Our reference: P-1116581-B2X8
Contact: Peter Wood
Telephone: (02) 4732 7577

2 April 2026

Council Response to Request for Advice on EIS – SSD-92743706 – Mamre Road Data Centre at 706–752 Mamre Road, Kemps Creek

Appendix A – Council Staff Comments to the SSD – EIS

Figure 4.1 Location of Generators on Proposed Site (Red)

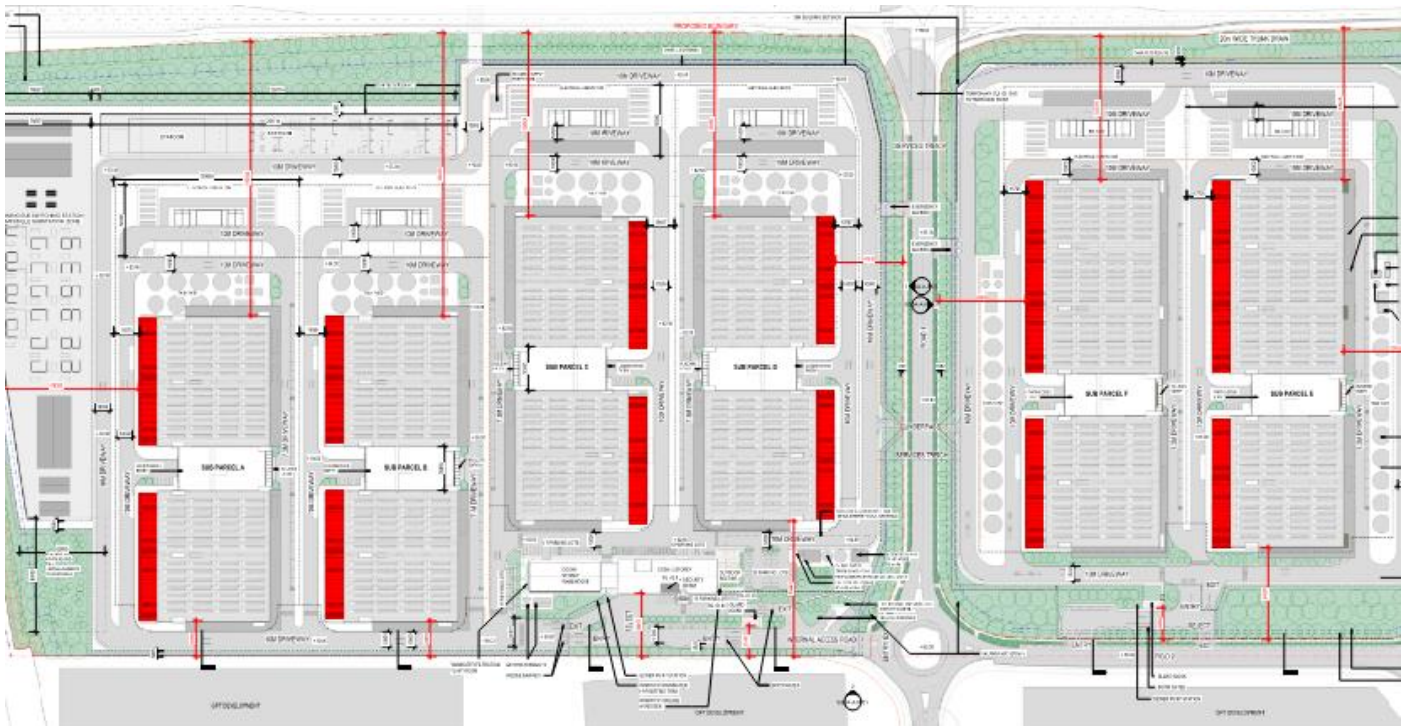
- a) The EIS states that regular maintenance and testing of the diesel generators will occur. It goes on to say that “Quarterly testing occurs with generators connected to mobile load banks at each sub-parcel. Only one generator per sub-parcel is tested at any time during daytime hours between 7:00am and 6:00pm. Testing procedures will not exceed the 200-hour exemption limit prescribed under Schedule 1, Clause 17 of the POEO Act.” Schedule 1 of the POEO Act states that internal combustion engines for emergency stand-by plant

- b) The regular maintenance schedule is based on one generator per sub parcel being tested. The sub parcels are set out as per the table below taken from the EIS

- c) There is a total of 30 sub-parcels, meaning that a minimum of 30 generators will be tested each quarter. Based on this, there are 120 instances of generators being tested over a 12-month period. No information has been provided on how long each generator is tested for; however, they have determined that they will be tested during the daytime, between 7am and 6pm. More information should be obtained as to how long each diesel-powered generator is operated for during each test.

- d) In addition, no maintenance schedule has been provided; therefore, it is possible that the generators will be tested more frequently. The question is raised regarding this lack of information: could the length of the testing, coupled with more frequent testing, result in the facility being subject to Schedule 1 Clause 17 of the POEO Act? More information should be obtained by the consent authority prior to determination. It is understood that backup generators are likely to require testing more frequently, with all generators needing to be tested (not just one per bank) to meet customer needs and confidence in the facility.

RETAINING WALL RW01 PROFILE
SCALE 1:500 HORI.
1:500 VERT.

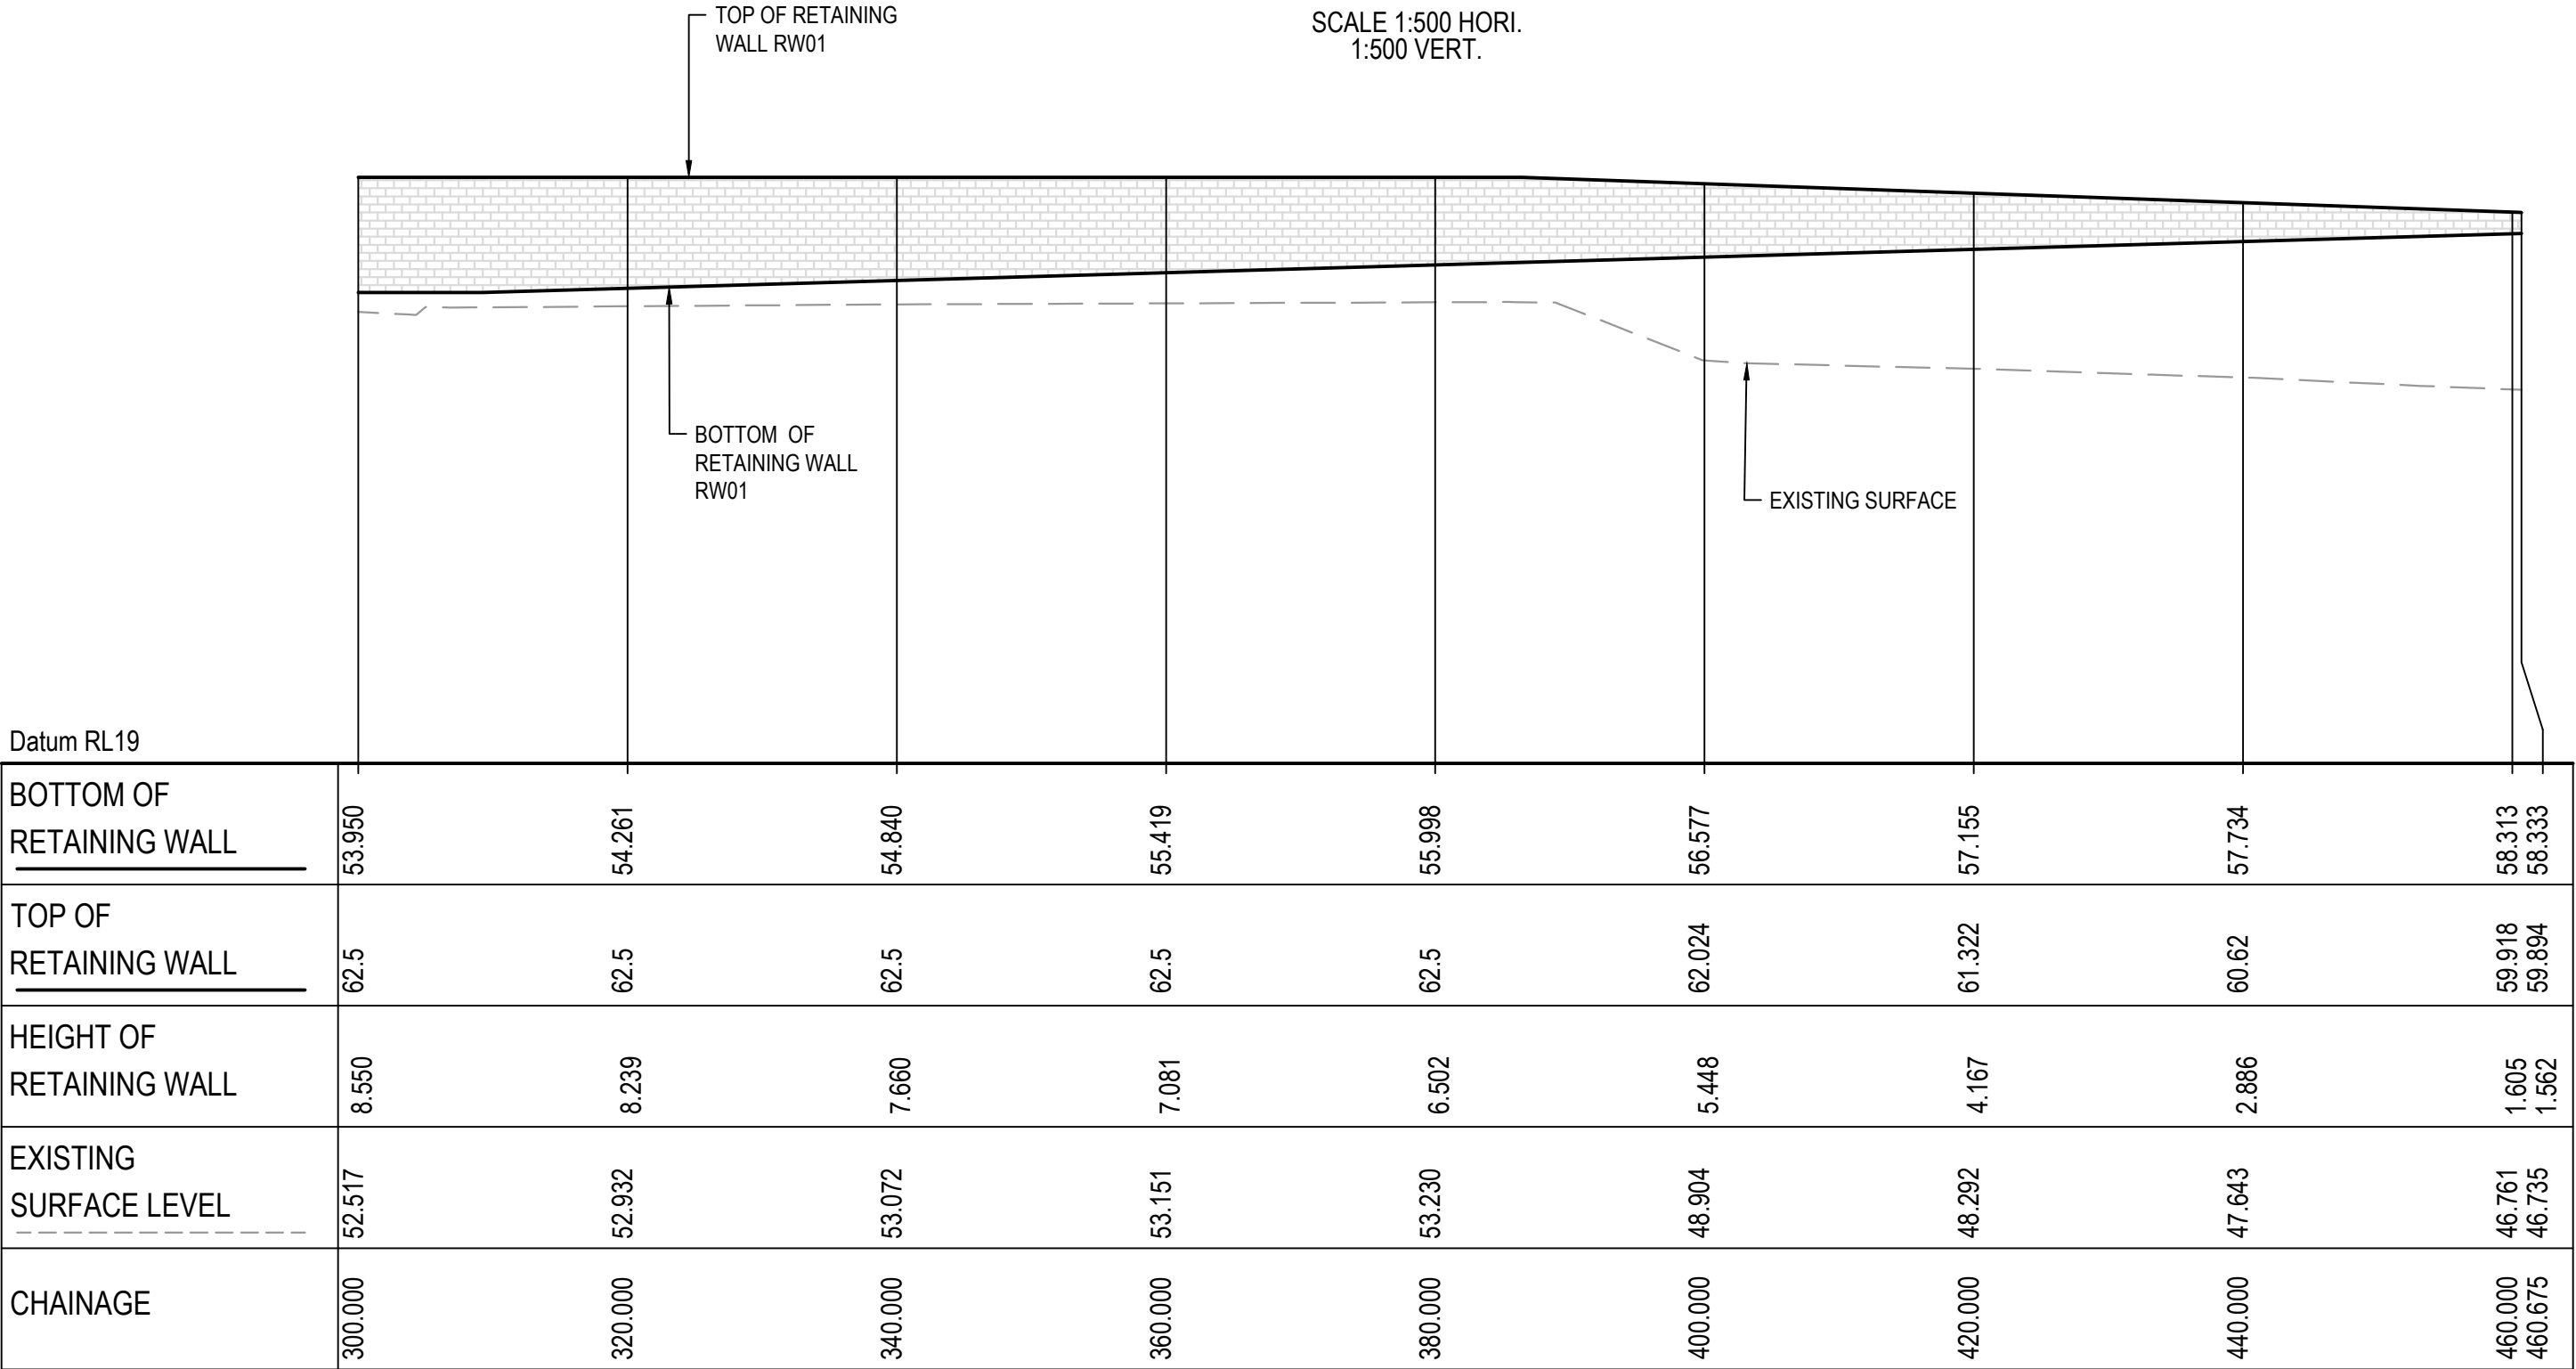
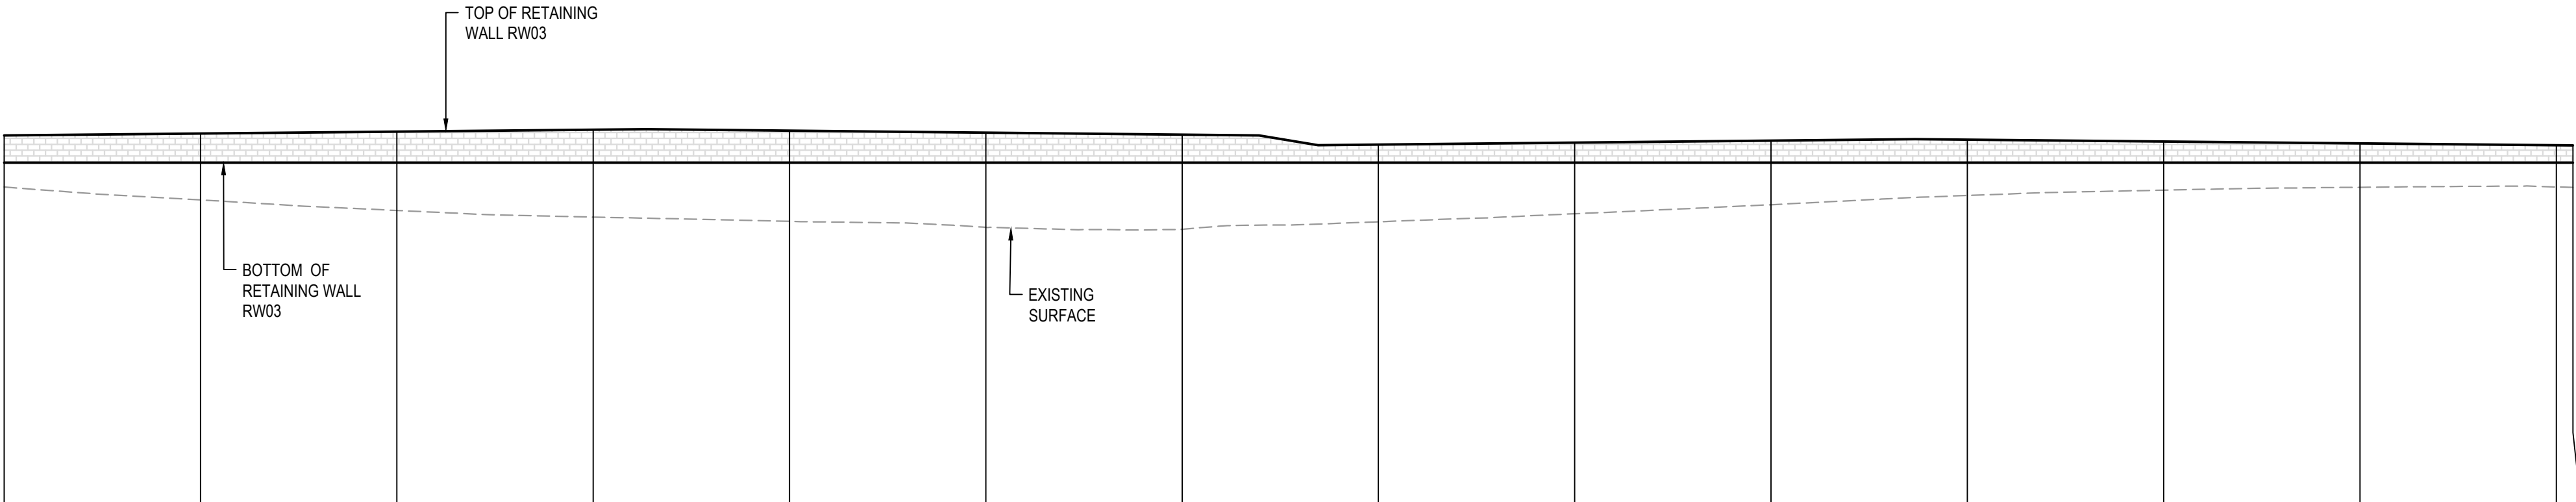
- n) Given the significant non-compliance with height and the extent of external infrastructure, as well as the high screening elements, the proposed tree planting and canopy coverage will not provide the required visual screening of all structures. The use of retaining walls in landscaped setbacks (particularly along the Mamre Road frontage) diminishes the ability to provide desired landscaping. The proposed building forms will continue to rise above the top of the full-growth tree canopy. This does not meet key objectives and controls of State Environmental Planning Policy (Industry and Employment) 2021 and of the Mamre Road Precinct Development Control Plan 2021.
